Application for removal or variation of a condition following grant of
planning permission. Town and Country Planning Act 1990.
Planning (Listed Buildings and Conservation Areas) Act 1990

Number	34
Suffix	
Property name	
Address line 1	The Crescent
Address line 2	
Address line 3	
Town/city	Rustington
Postcode	BN16 2PF
Description of site location must be completed if postcode is not known:	
Easting (x)	504639
Northing (y)	102002

Glazed gable extension and the addition of a porch.	
Reference number	
R/25/21/HH	
Date of decision (date must be pre-application submission)	26/03/2021
Please state the condition number(s) to which this application relates	
Condition number(s)	
2. The development hereby approved shall be carried out in accordance with the following approved plans: - Plans

DRAWING: 2120/05 REVISION:

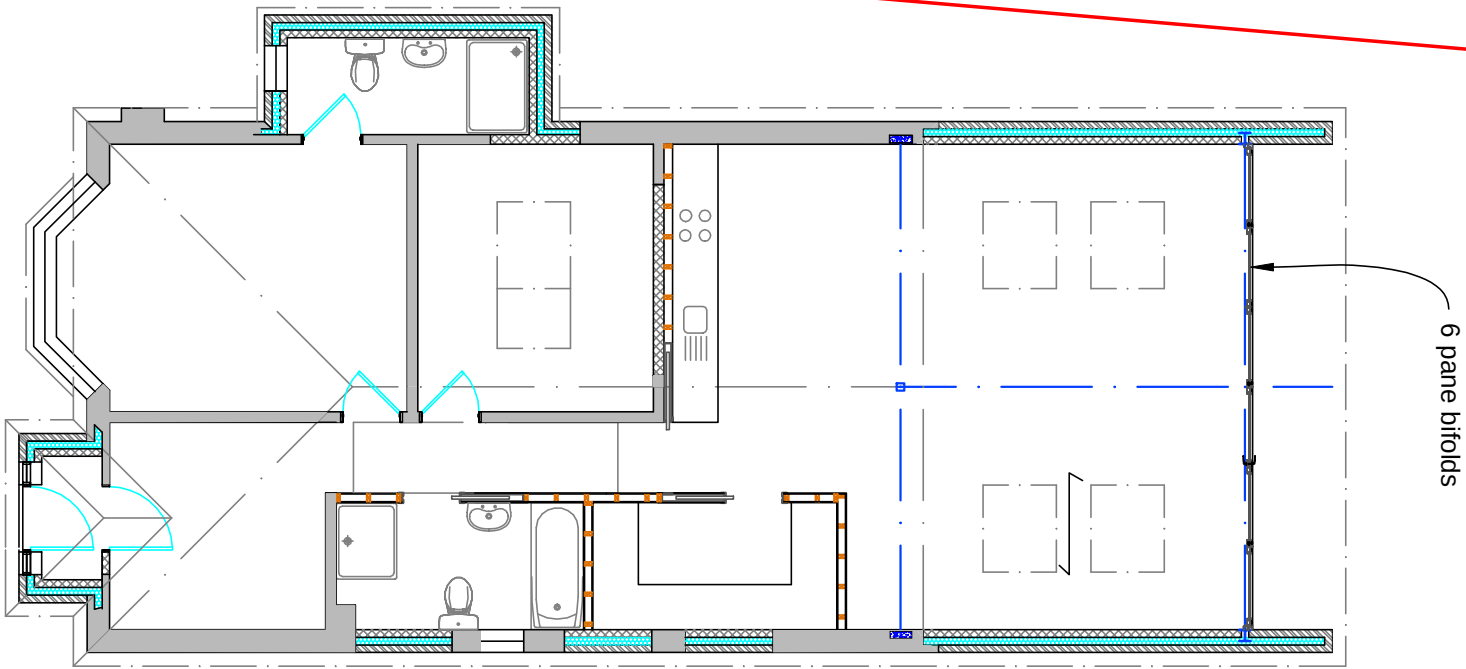
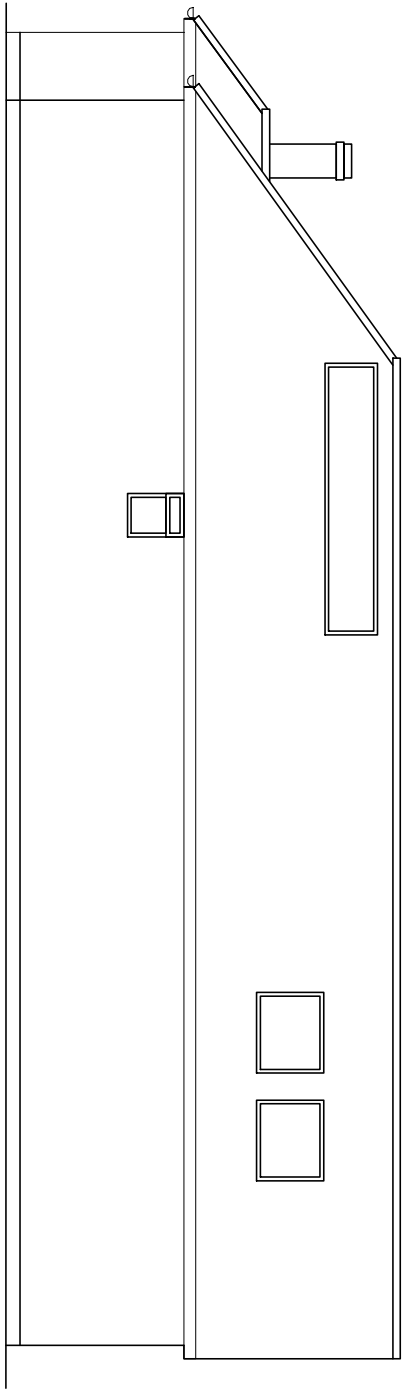
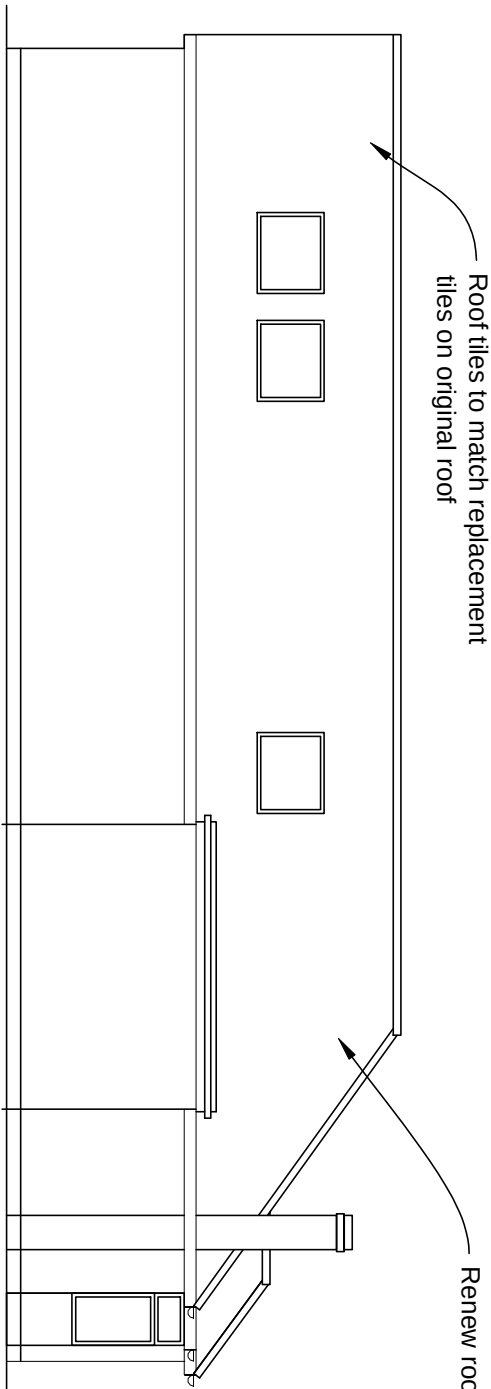
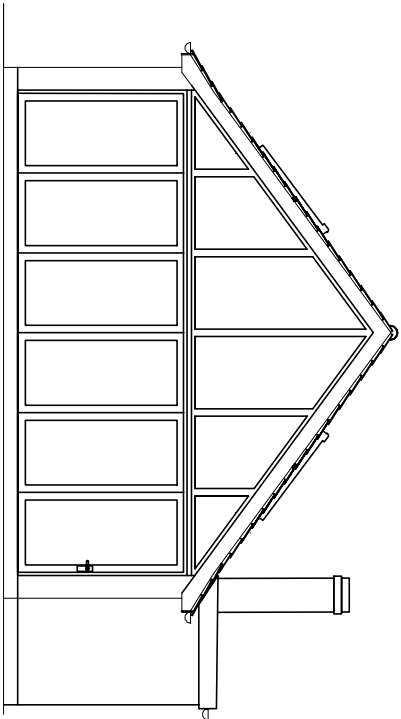
1. Roof coverings were found to be at the end of their useful life and replacement tiles to match the existing could not be sourced. The original roof coverings were therefore replaced and the tiles over the extension sourced to match the replacement tiles to the original roof.

2. Bifold door widths as indicated on original planning drawings could not be supplied by manufacturers, so the narrower door widths available meant that the number of leaves had to be increased from 4 to 6.

3. The work in this area of the property is not yet completed, with the original window openings not yet closed off. The actual proposed openings are to be reduced, with the window opening in the pantry now being omitted. The original bathroom window is to remain in situ.

4. The window in the EXISTING outside wall has been closed off by the bathroom extension and, in order to provide light and ventilation, a rooflight installed over. The bottom of the opening is approximately 3.2m above floor level and the rooflight does not extend beyond the roof slope by more than 150mm.

Revised plans to be substituted for original planning drawings mentioned under condition 2. No actual alterations to the condition wording considered to be required as these only mention 'plans', with no drawing numbers or details specified.
